BORG PANELS (DA27/95 MOD 8) – EPA COMMENTS ON EIS

I refer to an email from Ms Pamela Morales of the Department of Planning & Environment to the Environment Protection Authority (EPA), dated 16 July 2015, seeking EPA comments on the Environmental Impact Statement prepared for Borg Panels and relating to the proposed installation of co-generation units at their Oberon facility (DA27/95 Mod 8).

The EPA has reviewed the EIS prepared by The Design Partnership, dated 26 June 2015, and offers the following comments and recommended conditions of approval should the modification be approved.

Figure 2: Noise Sources Location

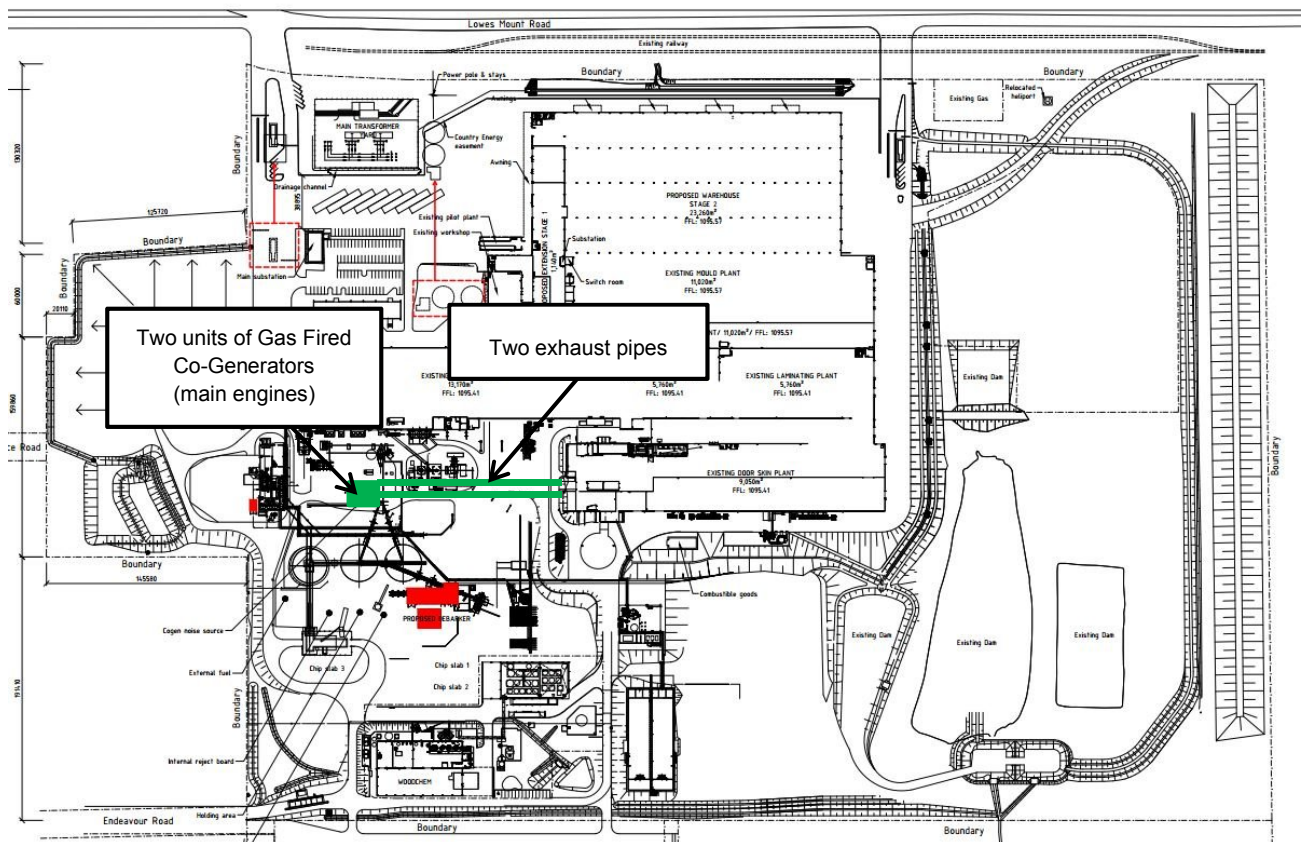
- There is no detailed explanation of how the generator exhaust sound pressure level is attenuated from 120 dB(A) at 1 meter to 68 dB(A) at 1 metre as described in the last dot point and in Table 8 on page 12 of Noise Impact Assessment respectively;

- While the EIS provides no details on the nature of the noise attenuation to be undertaken at the co-generation unit enclosures, Section 6.3 of the Noise Impact Assessment states that the enclosures will be lined with 50 mm thick Rockwool sheets; and

1. The co-generation units must be acoustically treated in order to achieve the predicted levels that have been described in the Noise Impact Assessment.
2. The proponent must undertake post commissioning noise monitoring to demonstrate that the operation of the co-generation plants does not result in the exceedance of noise limits at noise sensitive receivers as identified in Section 7.0 of the Noise Impact Assessment.
